**Application by Norfolk Boreas Limited for the Norfolk Boreas Offshore Windfarm.
The Examining Authority's written questions and requests for information (ExQ1)
Issued on 19 November 2019**

Please find attached answers to the highway elements of your request from Norfolk County Council (NCC) in its capacity as Local Highway Authority (LHA).

ExQ1: Tuesday 19 November 2019
Norfolk County Council Responses
Identification reference: 20022890

Title:  
Bat Activity Survey locations  
(Map 5 of 16)

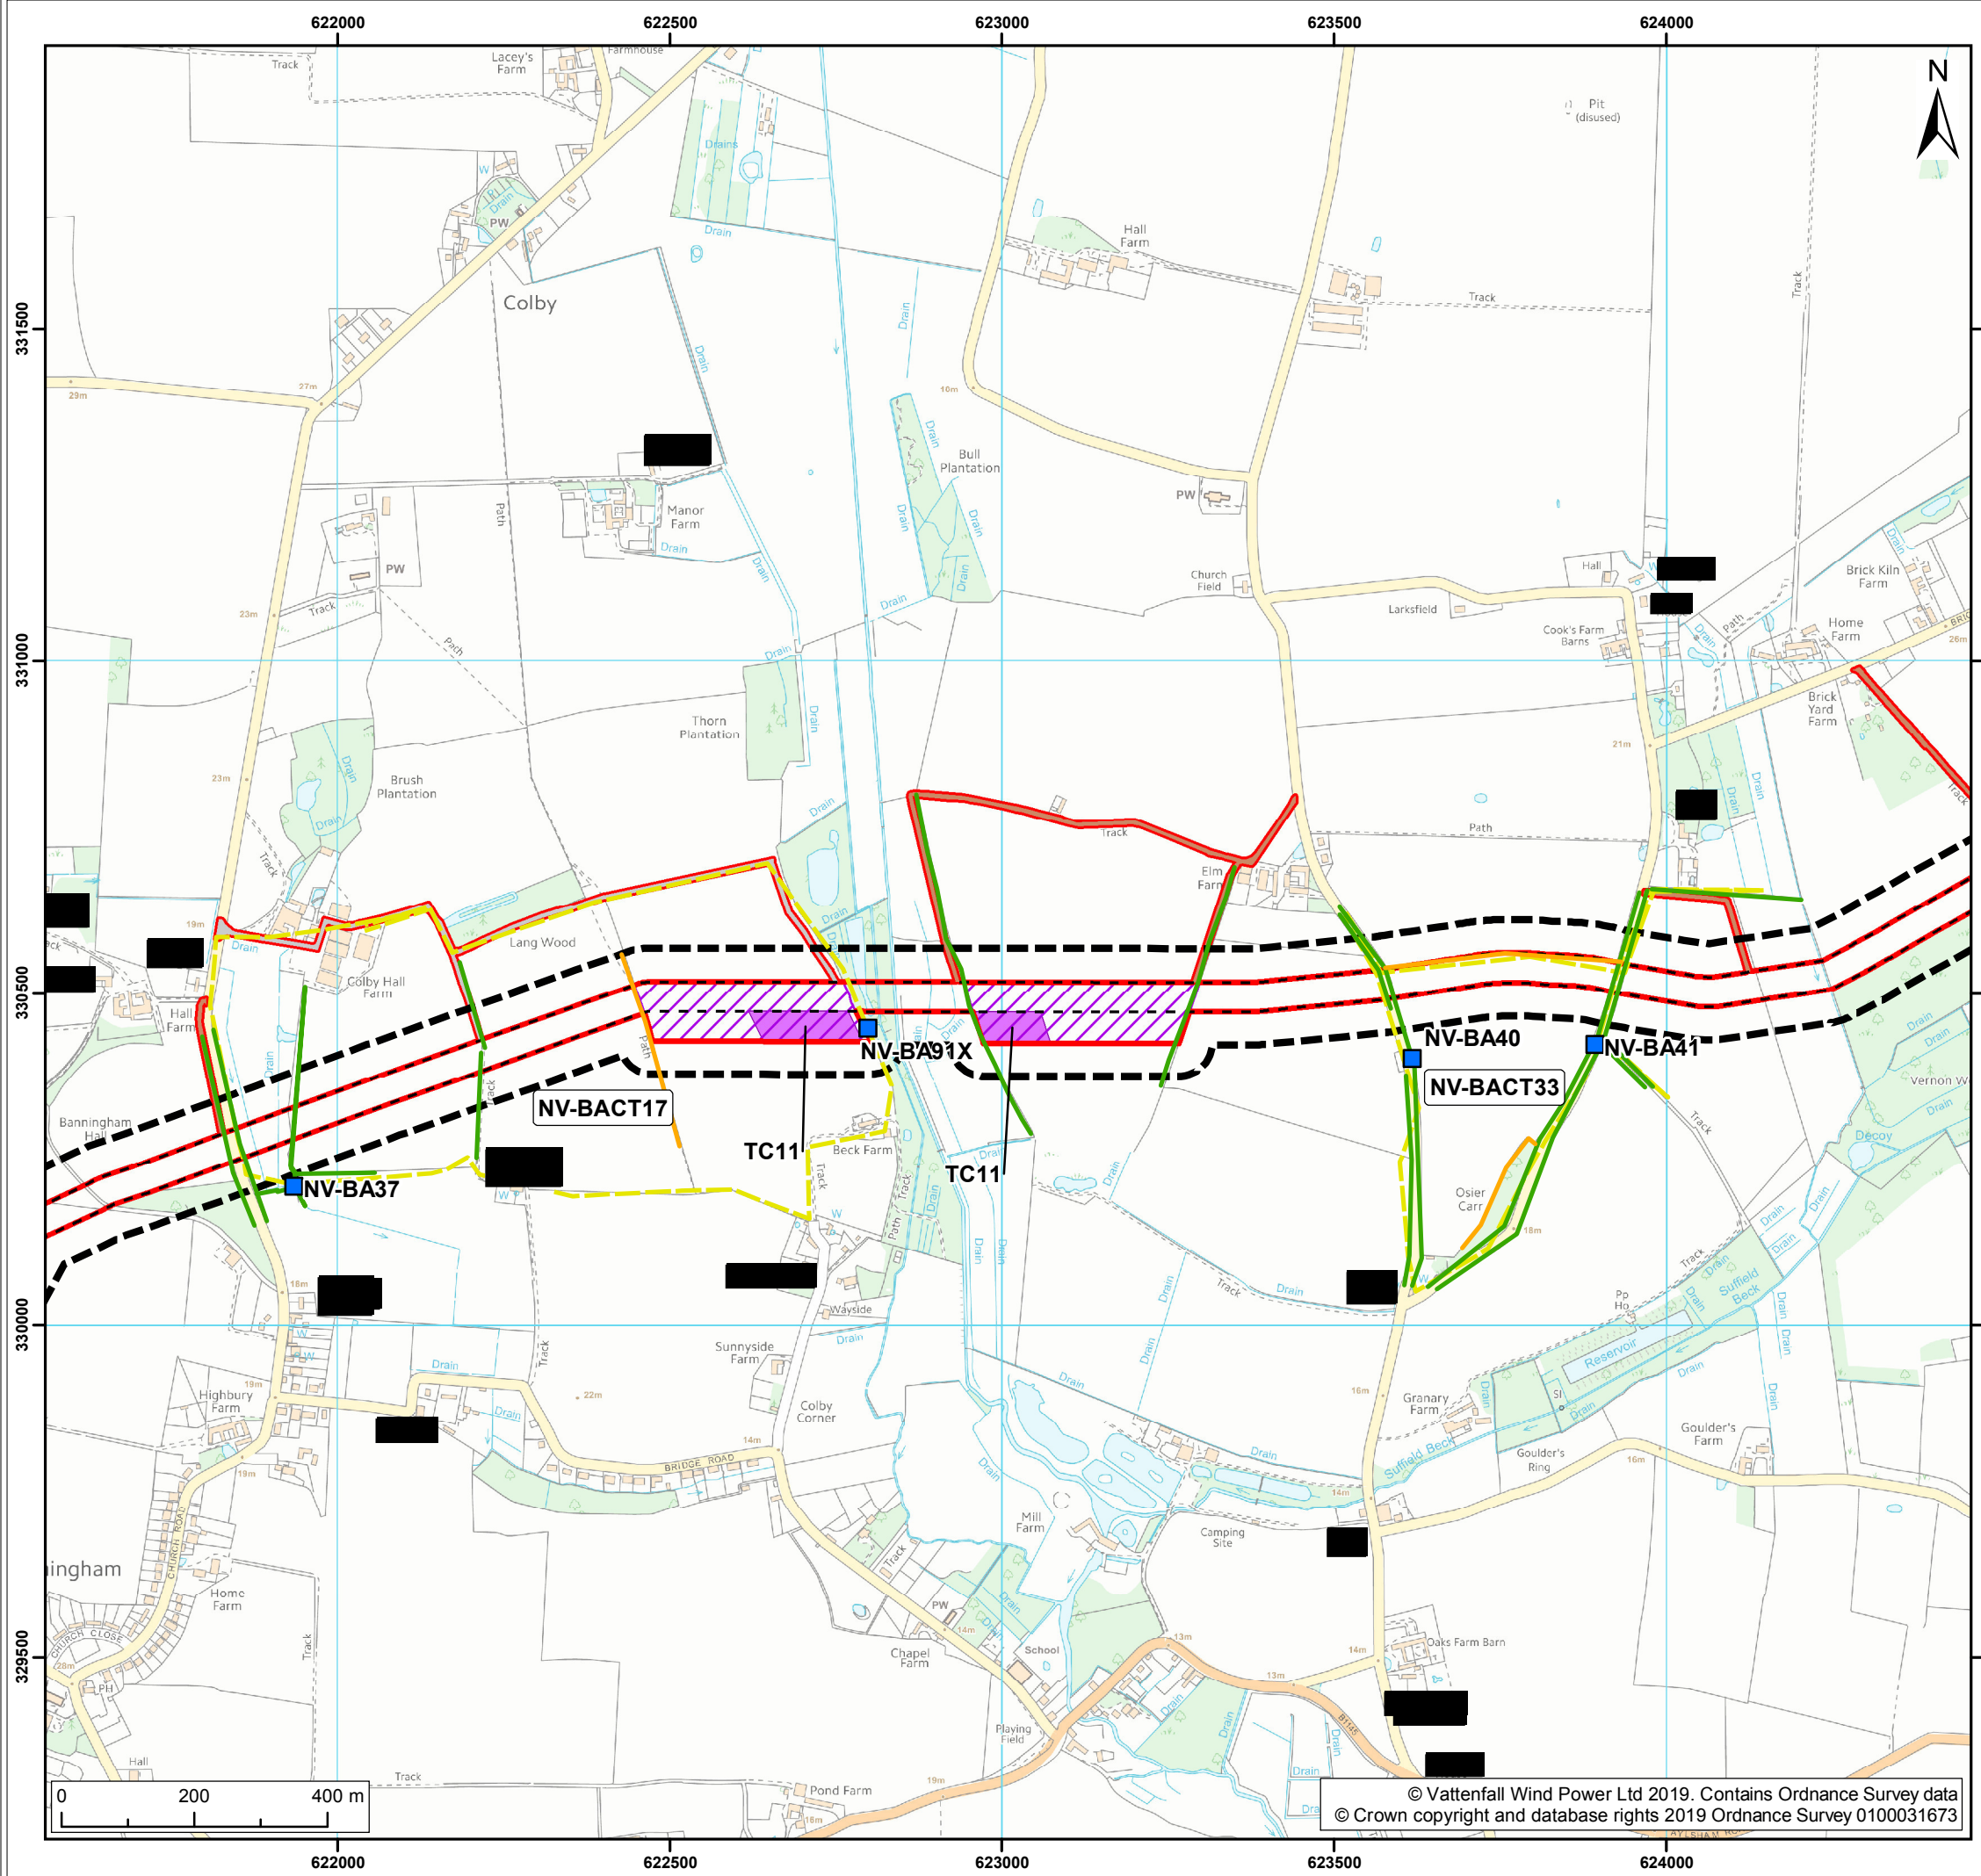
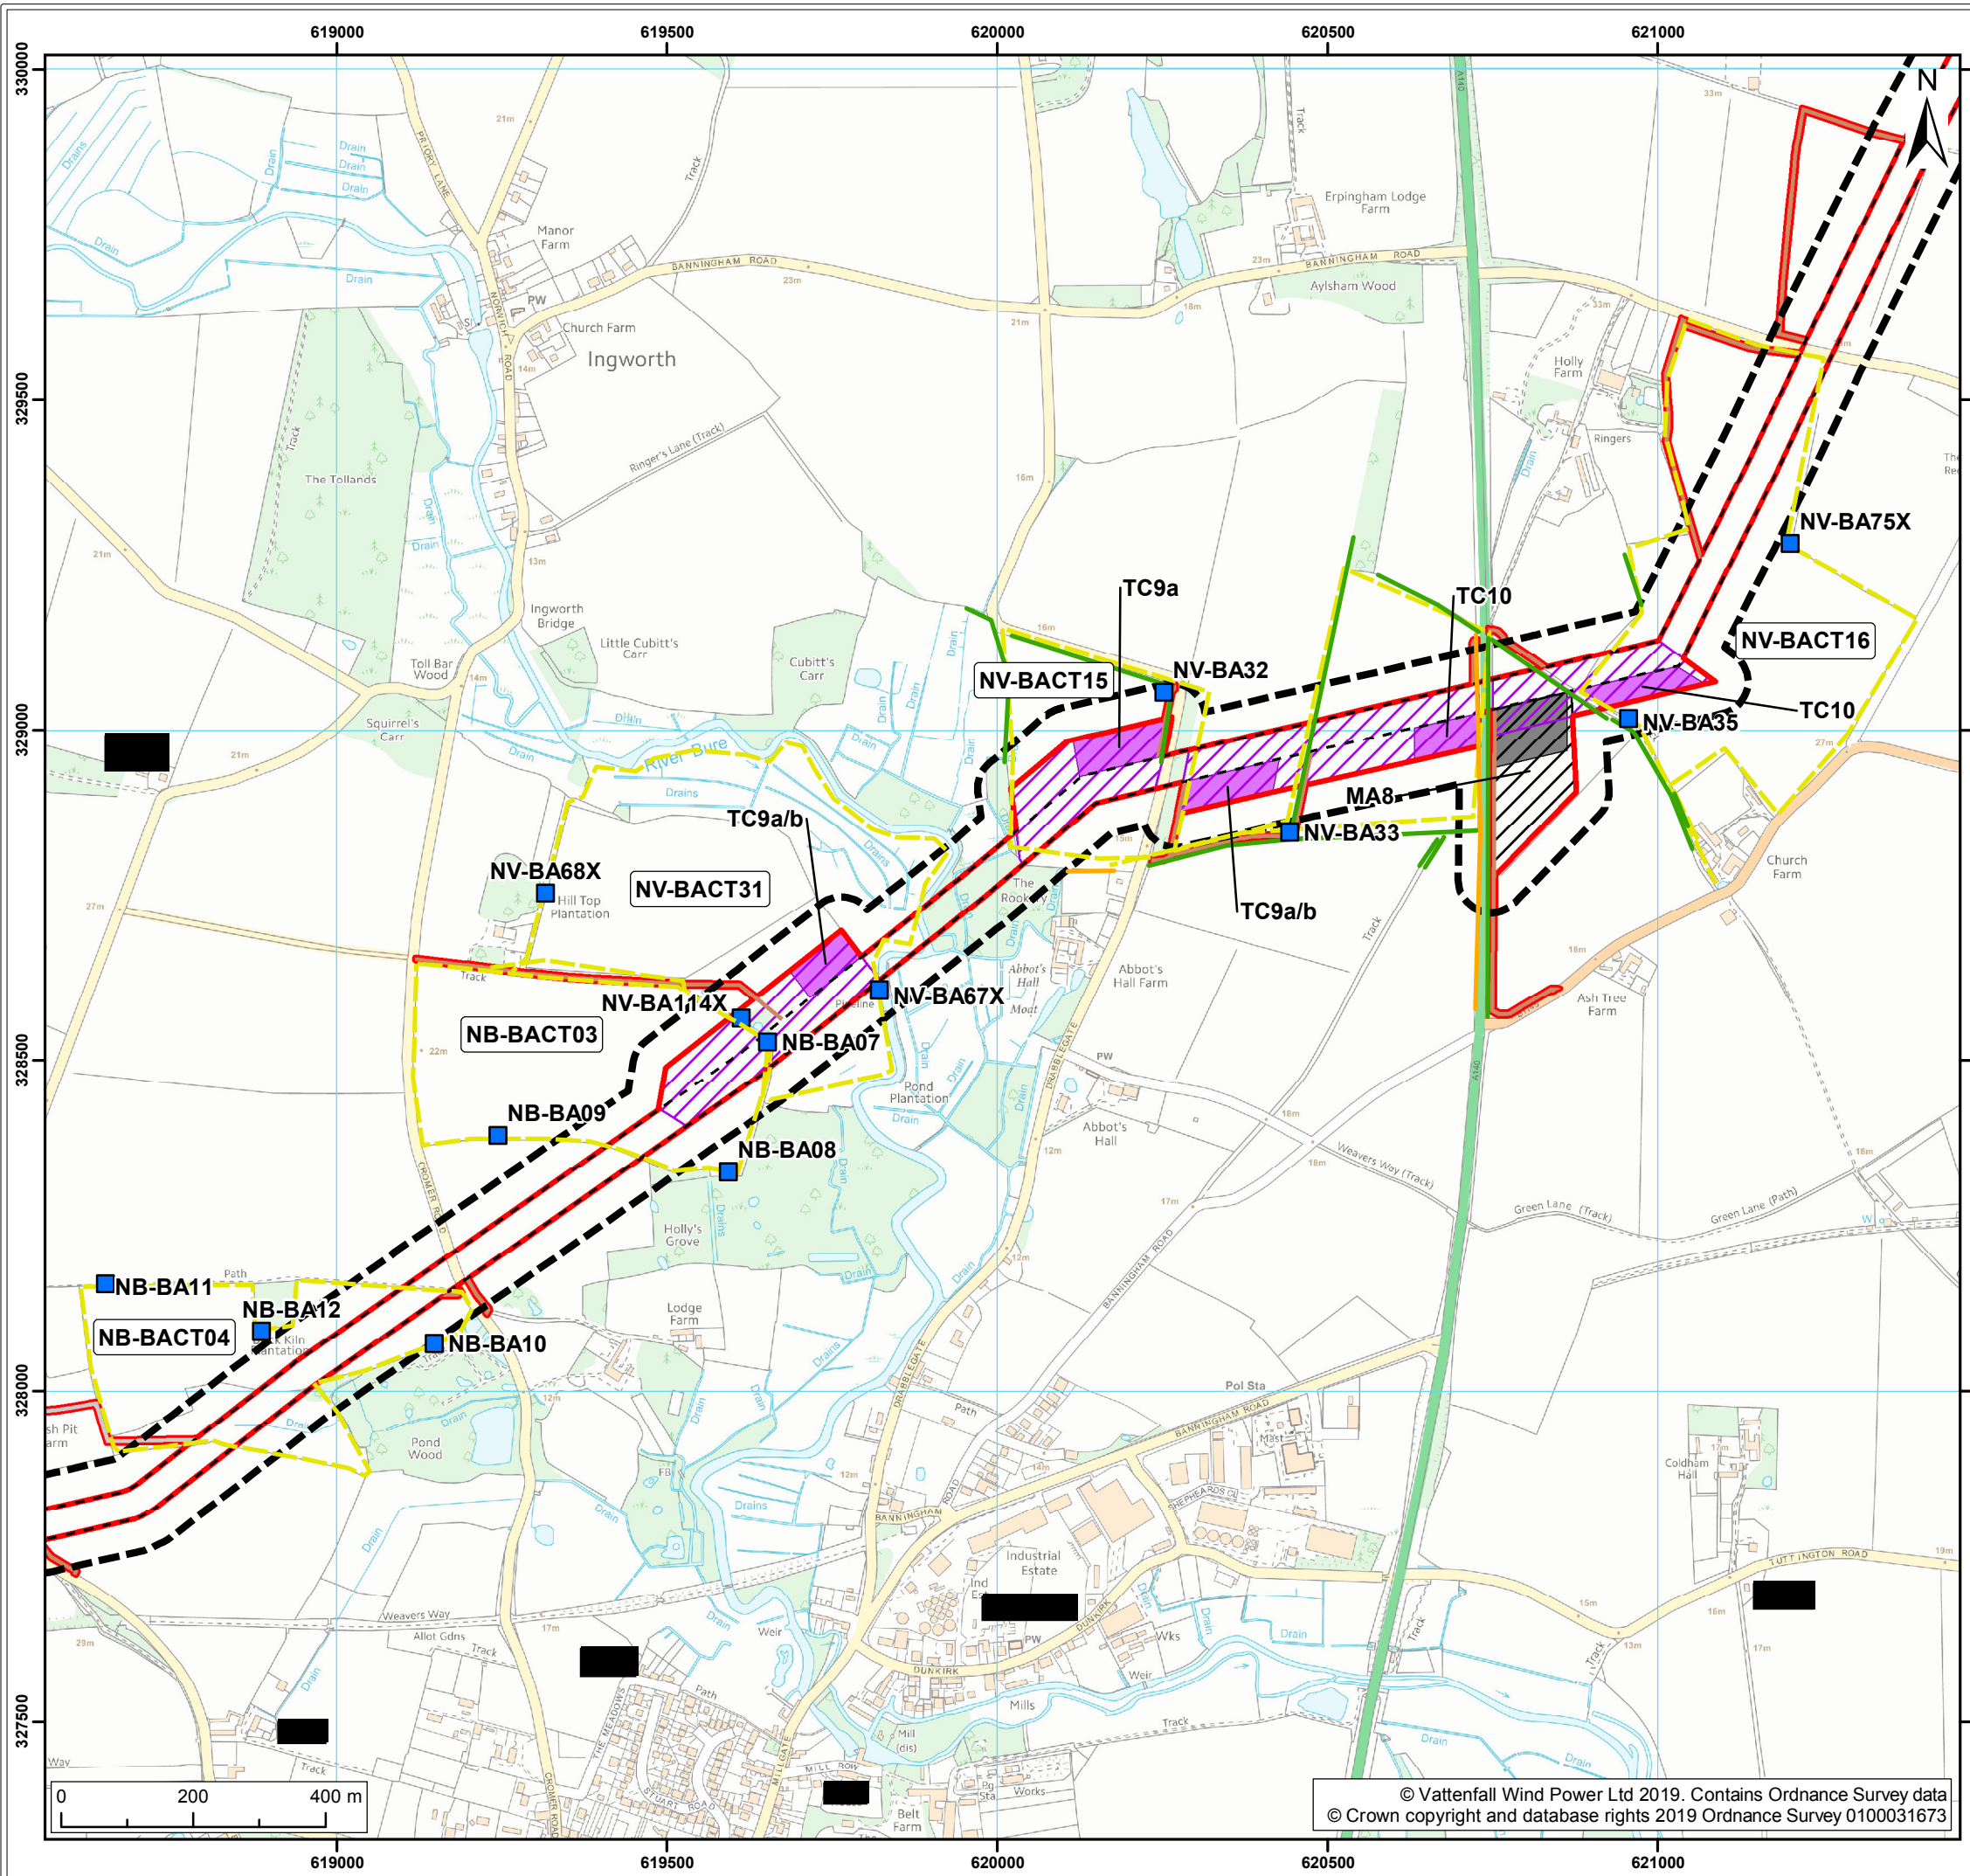
ExQ1	Question	Response
		<p>are? (Appendix 22.5² contains a report from November 2017; Appendix 22.04³ contains a report from February 2018 and Environmental Statement Figure 22.8 - Bat activity results⁴ contains maps from May 2018 showing bat activity survey locations, and Environmental Statement Figure 22.9 - Bat emergence results⁵ contains maps from dated April 2018).</p> <p>4. Table 22.9 (page 30) indicates that radiotracking data and other species roost data was obtained from Norfolk Barbastelle Study Group for the onshore project area and a 5km buffer. This is a misrepresentation as the data, notably radio tracking data, relates to Paston Barn SAC only rather than, as indicated, all barbastelle roosts within a 5km radius of buffer of the entire cable route.</p> <p>5. Table 22.21 (page 78) – hedgerow loss will be restricted to that required for access beyond the two-year duct installation phase, and will be no wider than 6 m. In Table 22.23 page 84 it says hedgerow gaps will be 13m long, possibly extending to 16.5 if crossed at an angle. Please can this be confirmed. (see Chapter 5 Project description – not reviewed at this stage).</p> <p>Comments on Assumptions</p> <p>1. Paragraph 83/84. Biological records data provided by NBIS includes records made almost exclusively by volunteers, the great majority of these data are collected by amateur experts in their field. All records provided by NBIS have a</p>
